From: Martyn White
Sent: 11 December 2018 17:20
To: Planning.Responses
Cc: Amber Willard
Subject: WA/101/18/HH & WA/102/18/L

WA/101/18/HH & WA/102/18/L

The application is for the provision of a two storey extension, along with a new detached garage to be located within the front garden area.

CLIENT	Mr & Mrs J Waights	SCALE	1:100 @ A3
SITE	Holly Tree Cottage, The Street, Walberton	STATUS	PL / LBC
PROJECT	Proposed First Floor Extension	AUTHOR	AH
DRAWING	001 Existing & Proposed Floor Plans	DATE	12 11 18

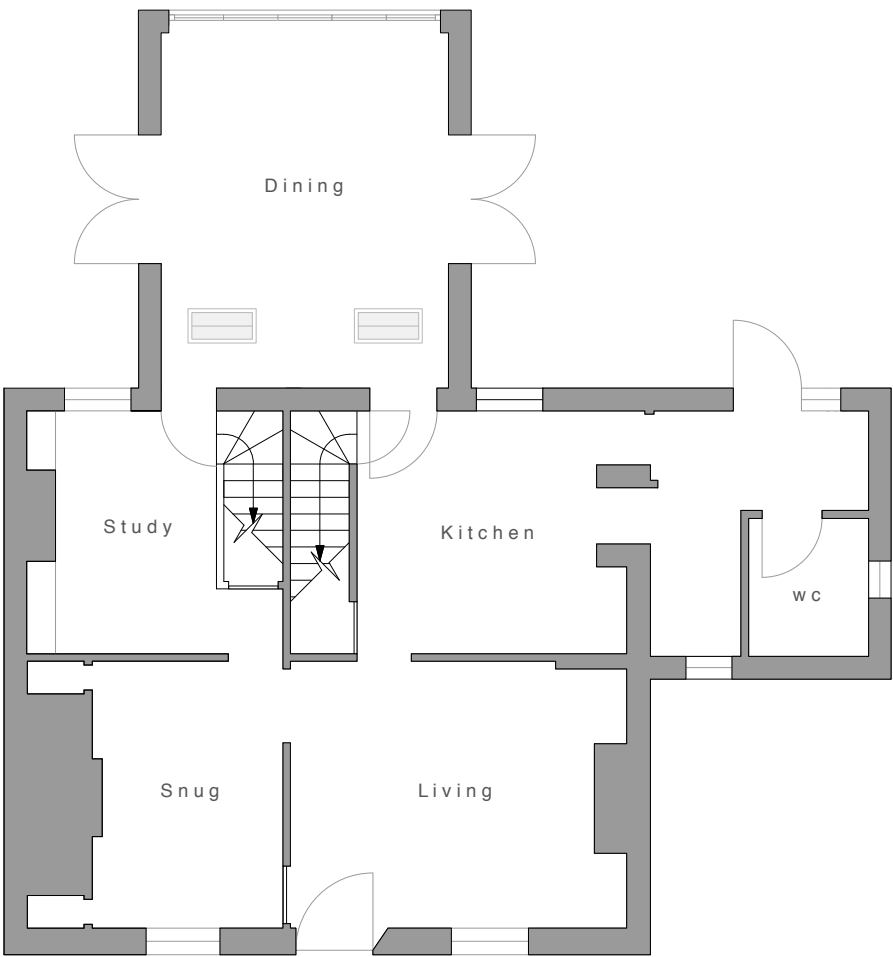
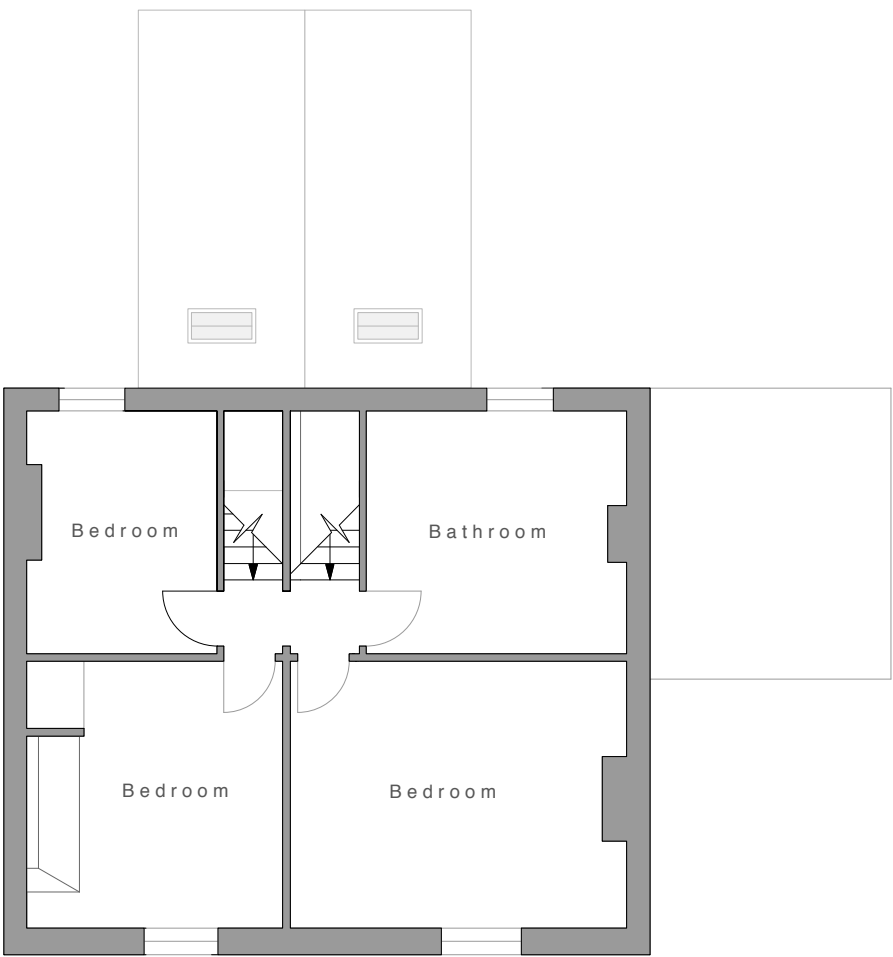
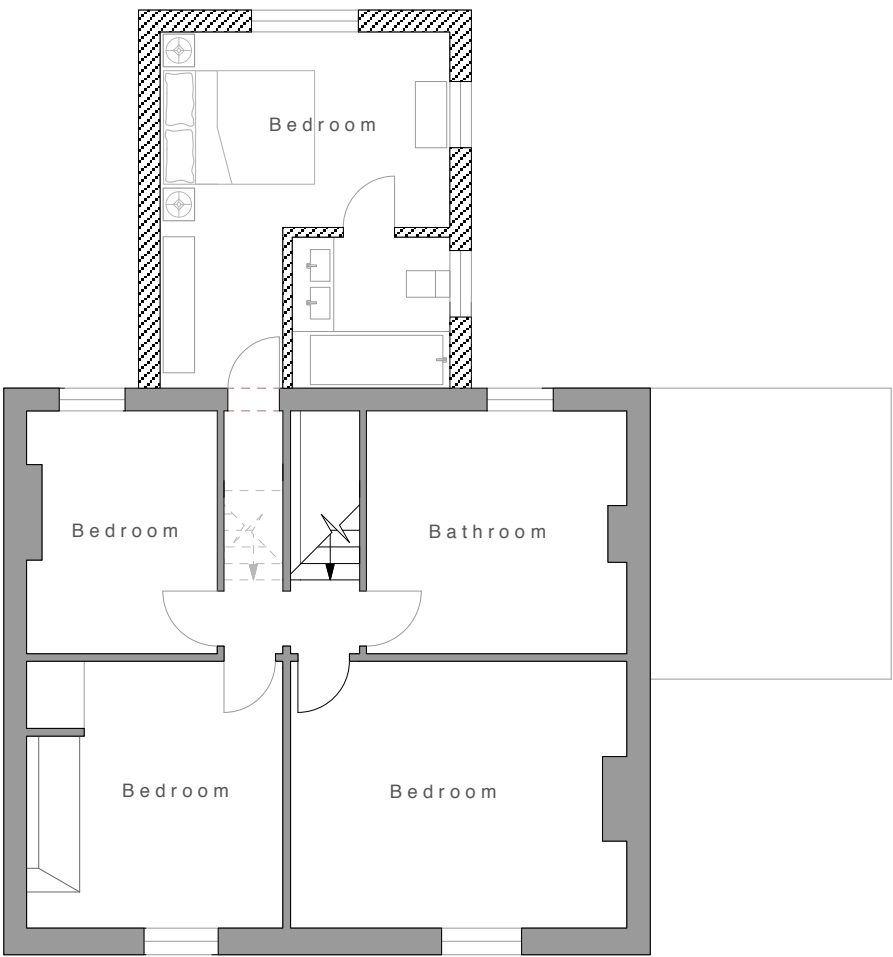
Further the proposed works to the stairs, whilst maintaining the historic fabric would harm the character, and therefore significance of the room.

Proposed Roof Plan at 1:100 scale

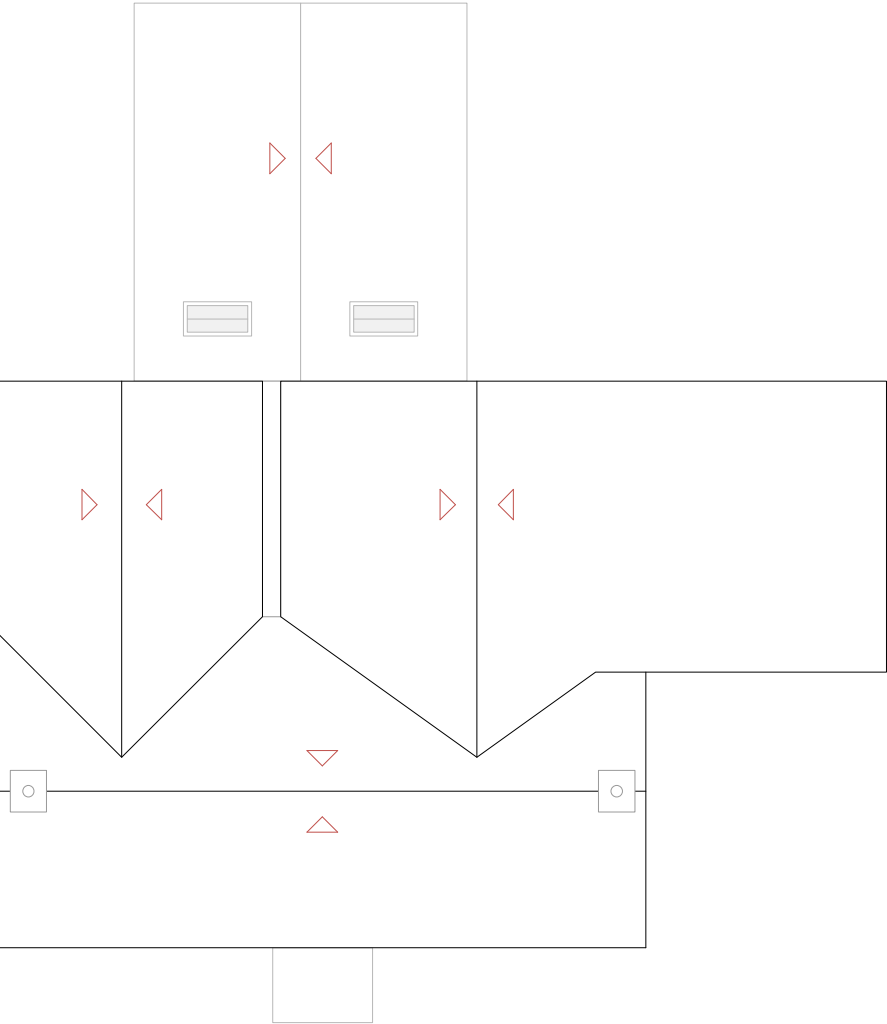
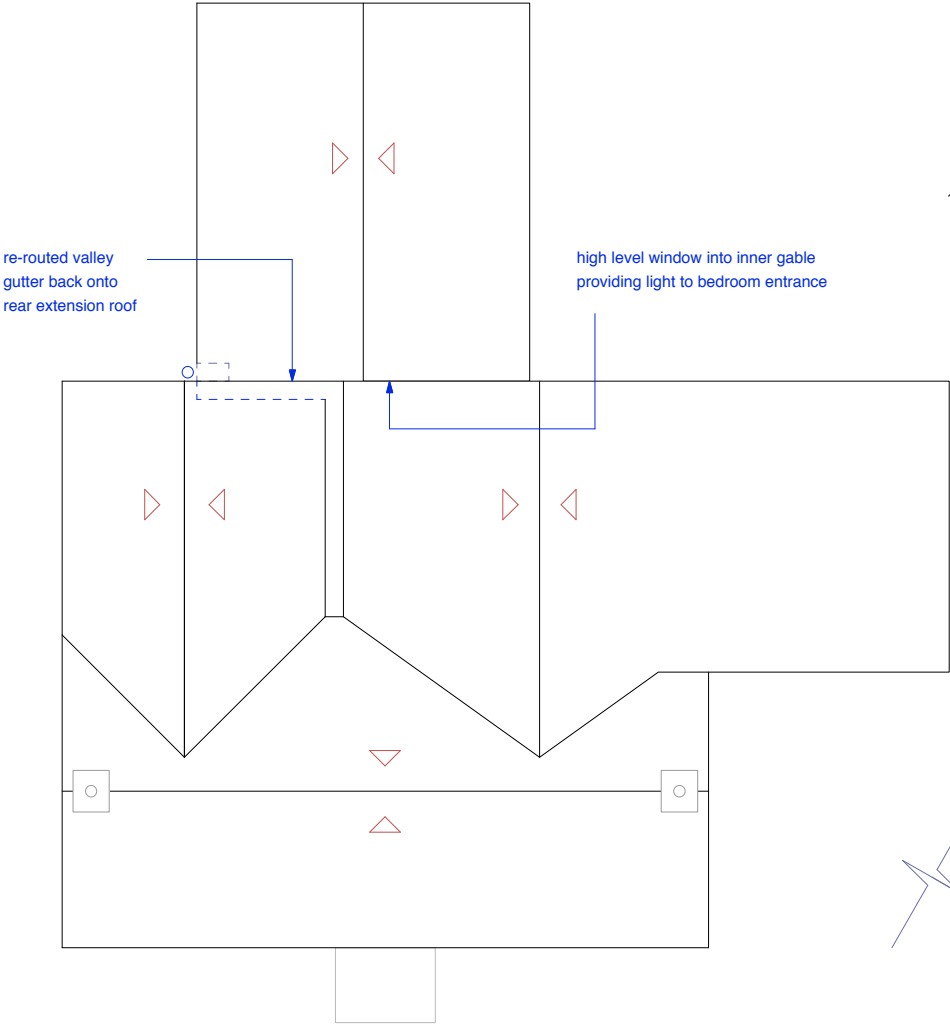
The extension would be sizeable and increase the mass of the existing modern extension. It is considered that it would dominate the rear elevation and be overlarge for the scale of the existing cottage.

The location of the proposed extension would surely mean that there would be issues with the removal of water from the existing valley in the section of roof directly behind the proposed extension. This would affect the design of the proposed extension, and requires further consideration?

Proposed Plan at 1:100 scale

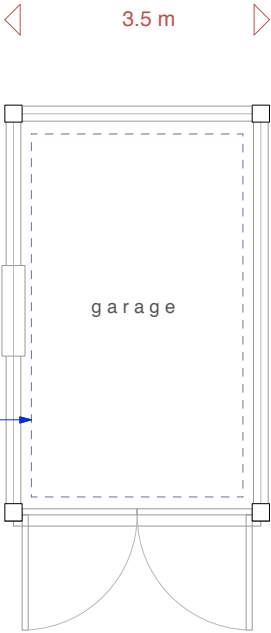
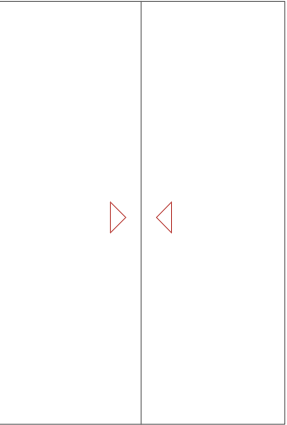
The proposed garage would essentially be built forward of the front elevation of the cottage on part of the existing parking area. At present the front garden area is contained by the flint wall and mostly laid to lawn with a small parking area for the resident's private car. Therefore, at present the cottage is fully visible from the street, and forms a focal point.

Development of the garage in this particular location will mean that it will play a dominant role in the street-scene and essentially block views of the listed cottage, so that only part of it is visible when looking westwards.

Further, the garage would be the only garage structure of this design, in this location in the conservation area. It is thought that out buildings are mostly masonry in construction, and therefore the proposed garage is of a conflicting design.
